Application No: R/18/22/HH
Site Address: 7 Evelyn Avenue Rustington BN16 2EJ
Description of works: Erection of single storey side and rear extension.

Thank you for your internet representation made on 9th March 2022 which has been recorded as an objection with the comments as follows:

Project: Proposed extensions; 7 Evelyn Avenue, Rustington BN16 2EJ	
Drawing: Plans and elevations as proposed	
For: Mr. & Mrs. A. Mullen-Orriss	
Drawn: PKS	Date: January 2022
Scales: 1:100 1:200	No: 2917/01/02
To scale when printed on A3

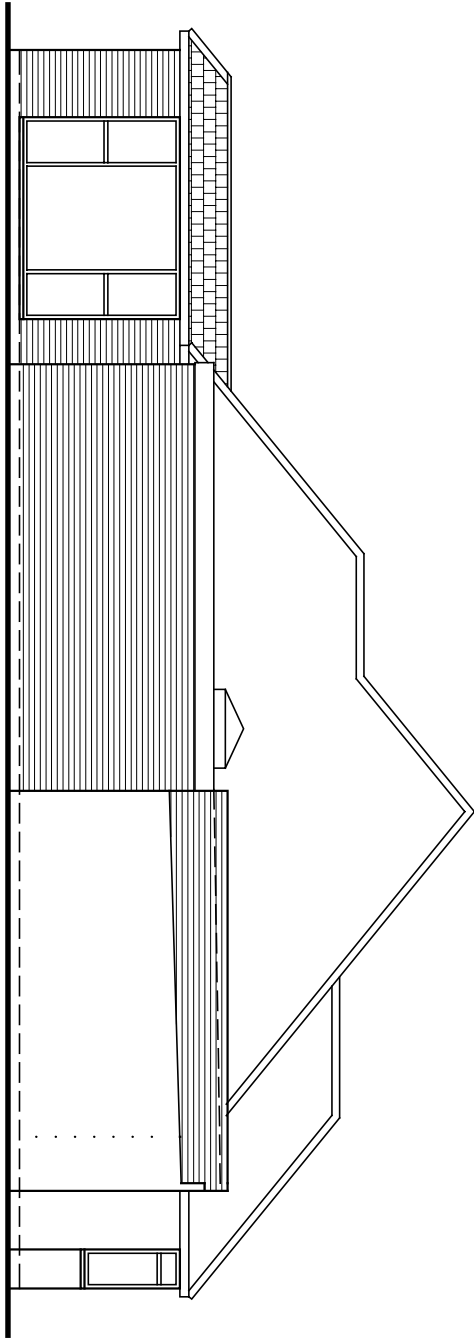
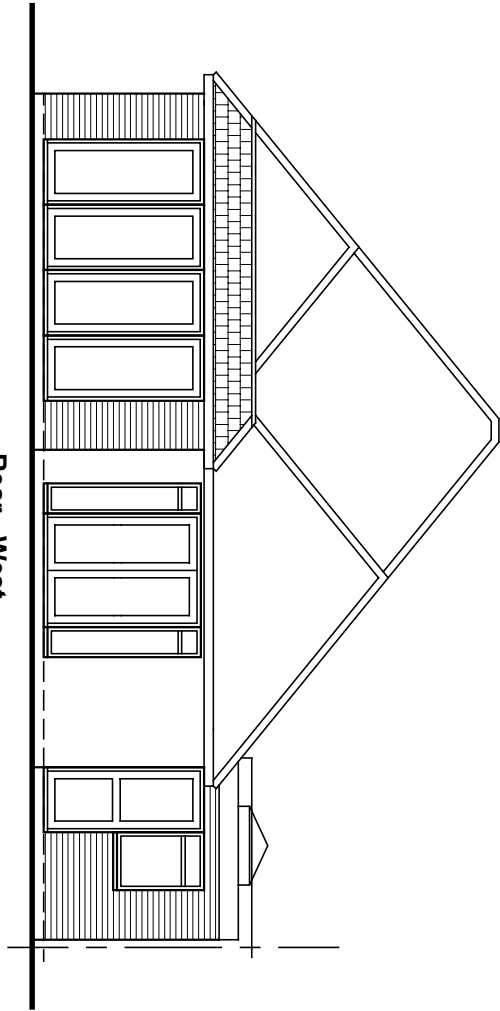
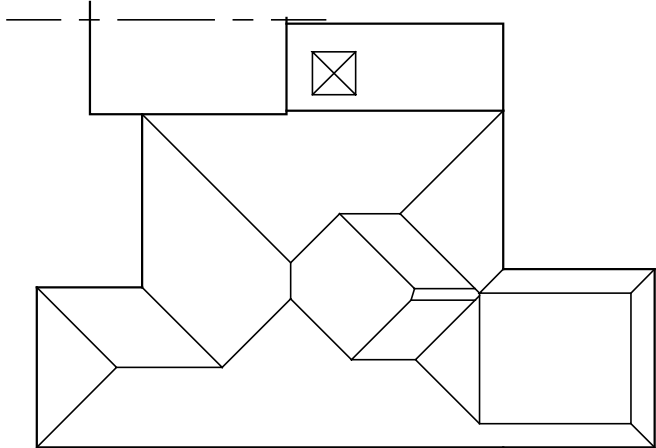
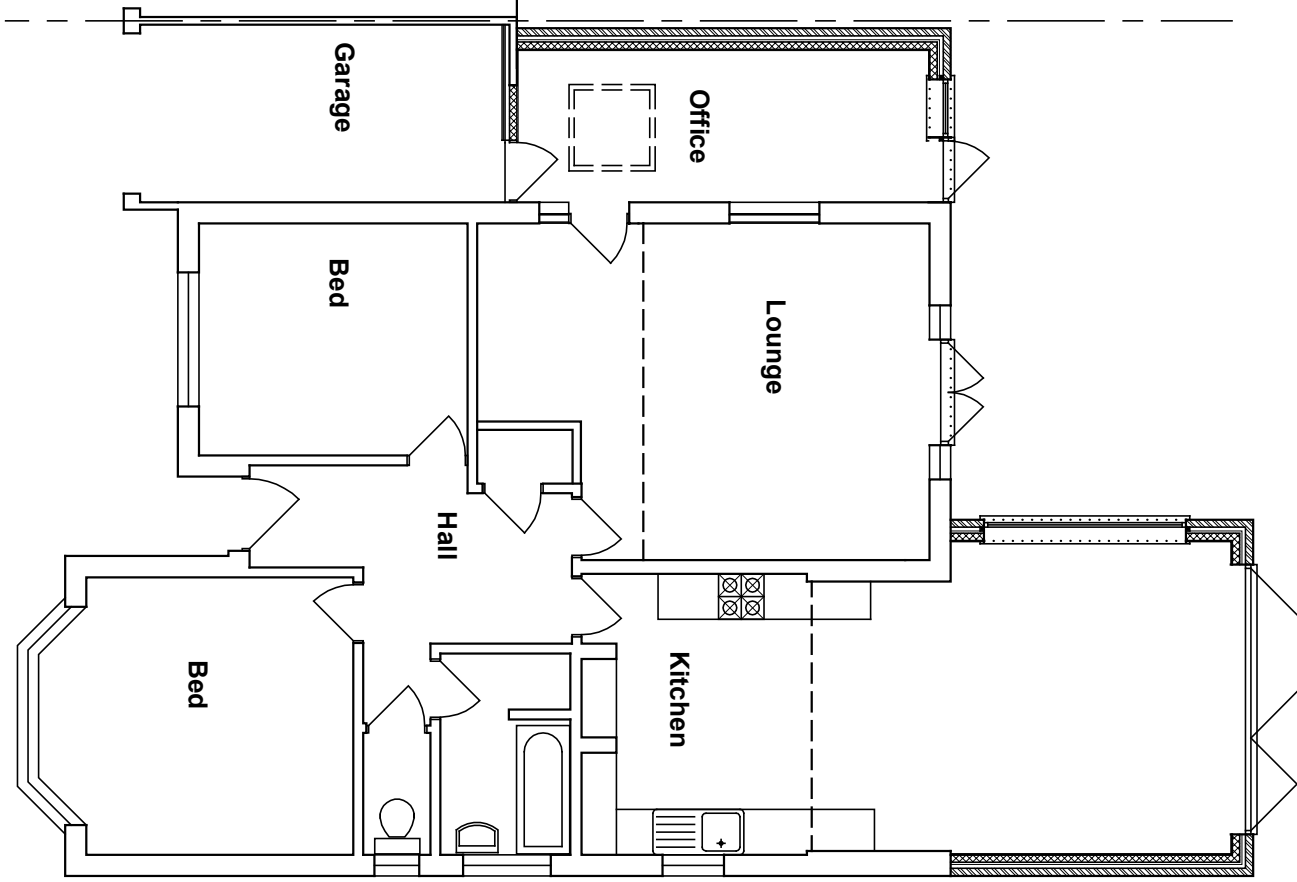
We object to the North side extension of the building due to overshadowing and loss of light to the rear of our property, in particular the Conservatory and patio making the kitchen and living room lacking natural sunlight. The kitchen has already been extended prior to the new occupants moving in, another extension to this would deem to be excessive and intruding on daylight entering our property. The sun is due South during the majority of the afternoon which shines directly onto this extension for the best part of the day.
